## **1/0349/2022/OUT**

Proposal: Outline application with all matters reserved No.1 low cost local needs dwelling

On Behalf Of: Environmental Protection Officer

Revision	
Proposed Dwelling	T11 Site Plan AS PROPOSED
at	
Halfpenny Land Rectory Road (B3217) DOLTON North Devon, EX19 8PX	Scale 1 : 500 A2 L sheet size.
for Mr H Jennings	Drq No. 798 25 rev: .

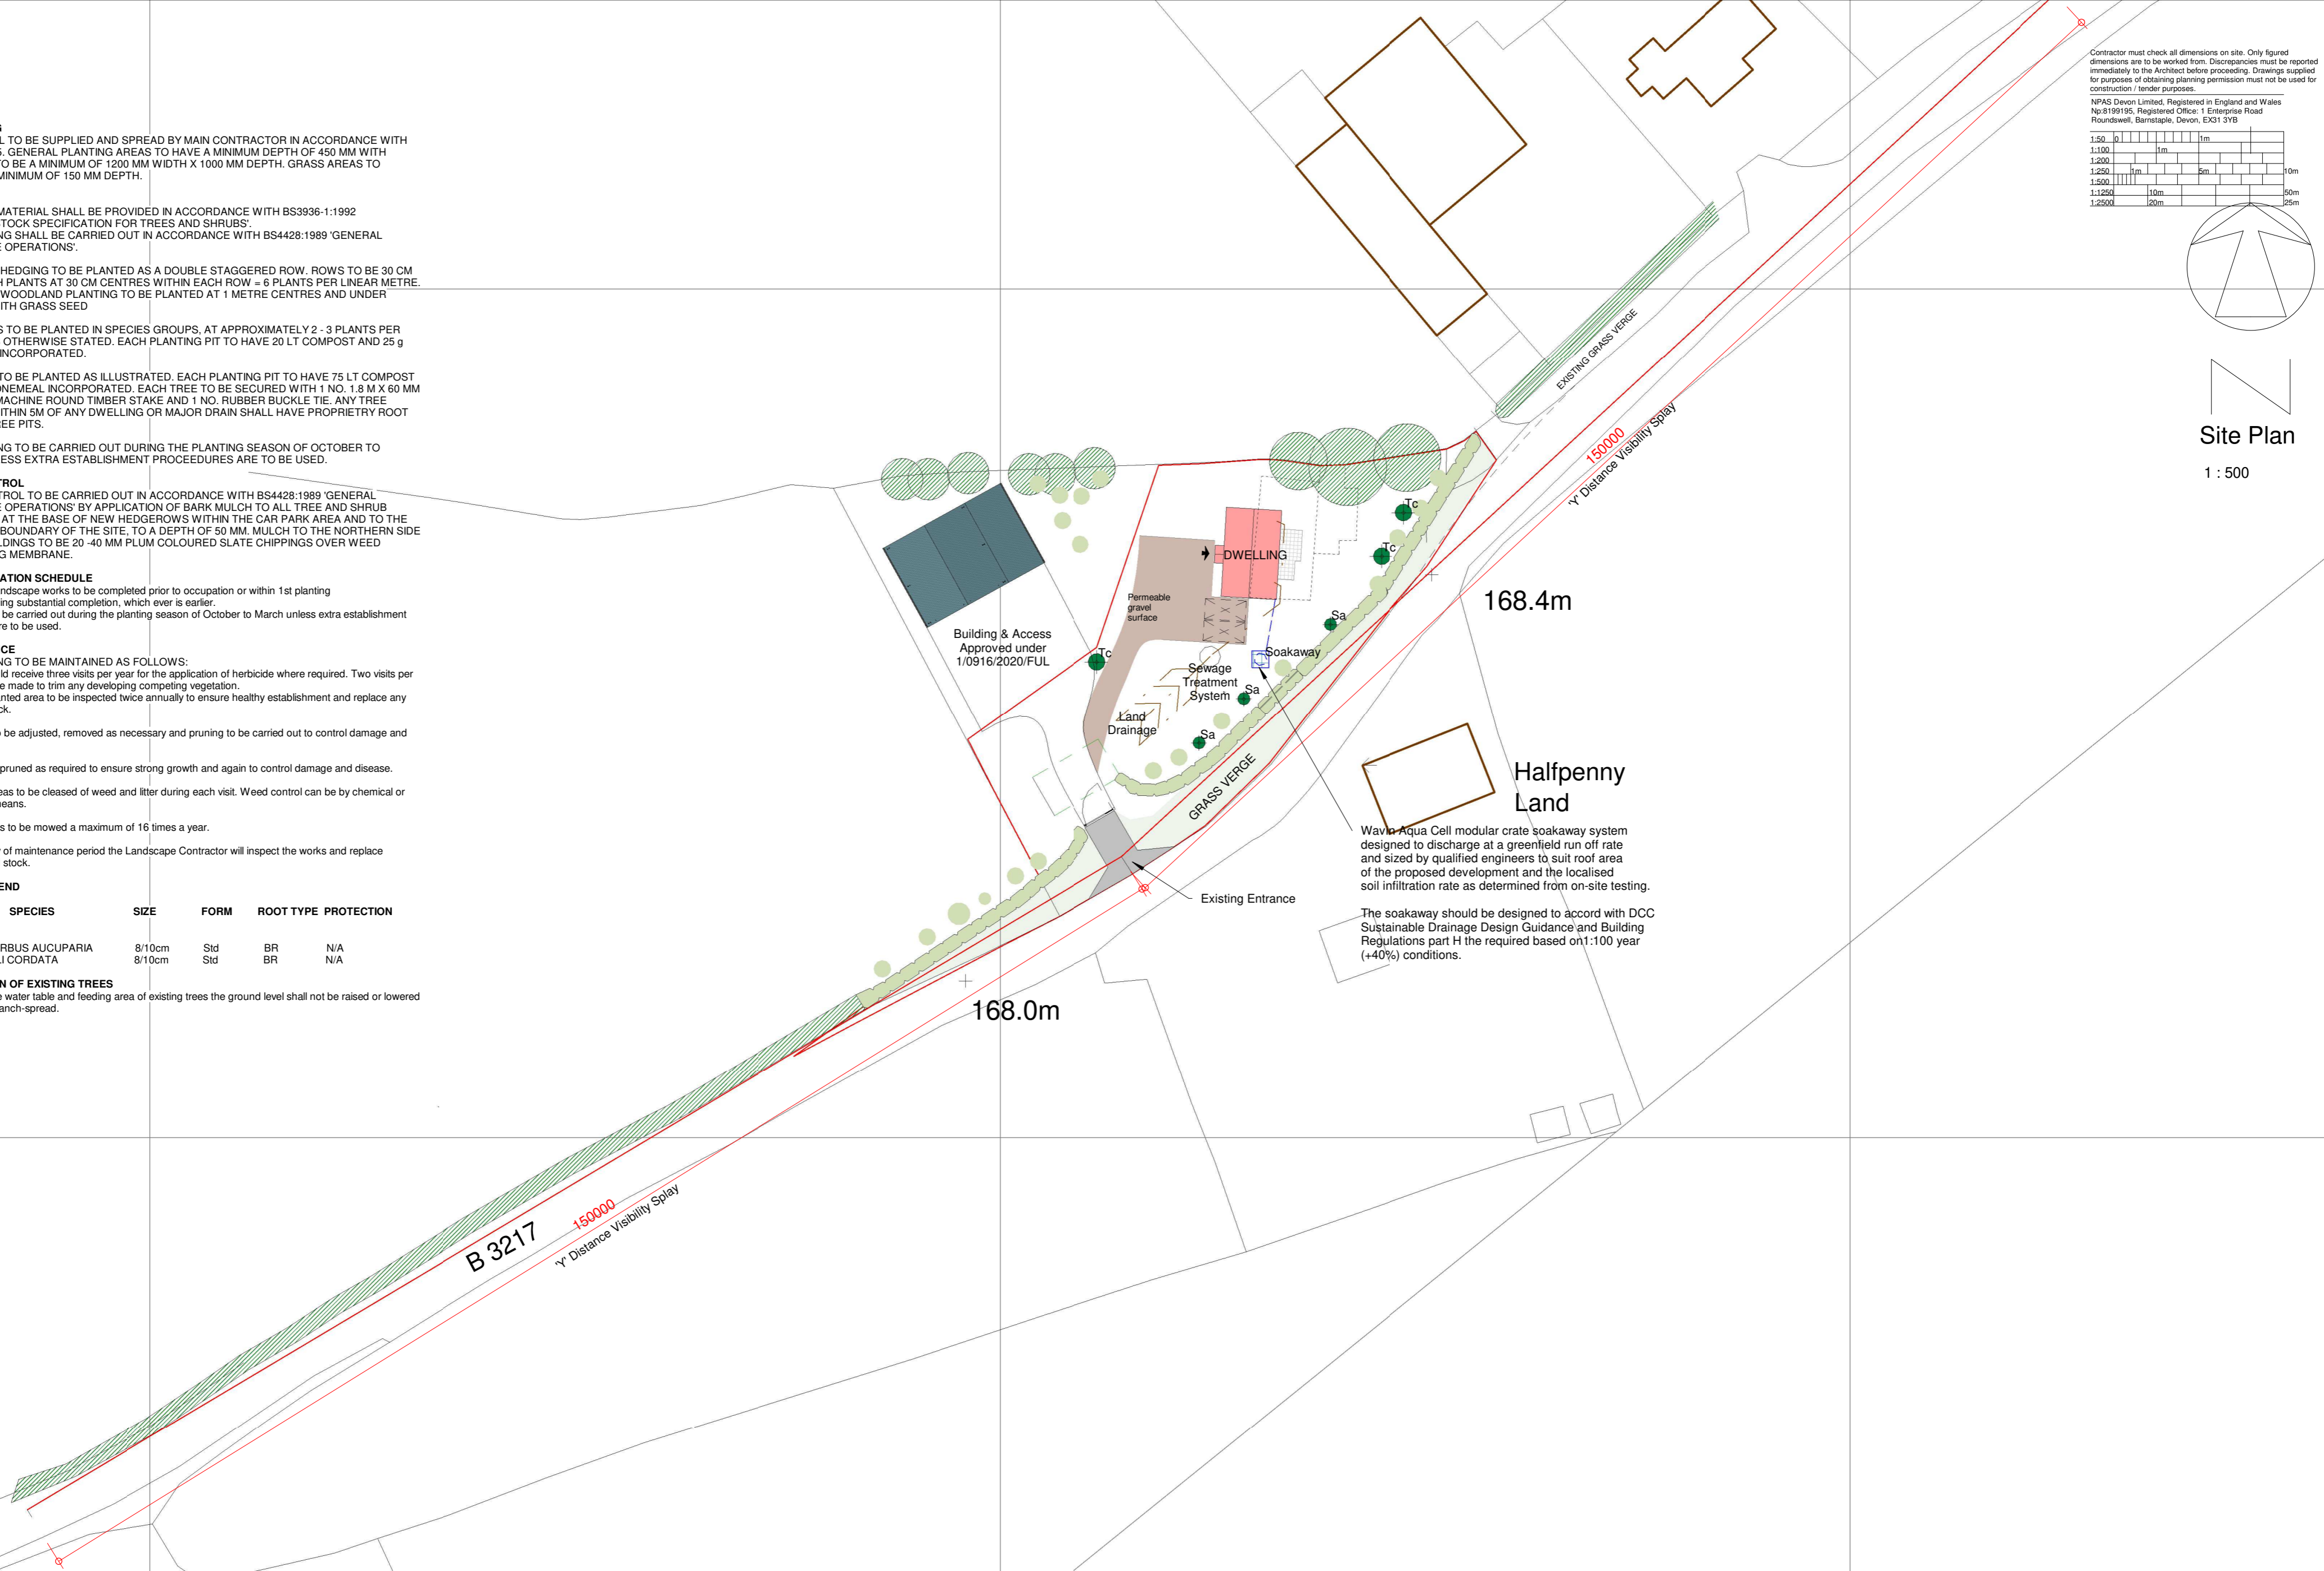
It is noted that the proposed dwelling will be served by a new package treatment plant discharging to a drainage field. There appears to be no percolation test results provided to assess whether the ground has suitable permeability to accommodate a drainage field. The applicant will need to provide further information on the foul drainage provision including a FDA assessment form, percolation tests, calculated drainage field area required and location.
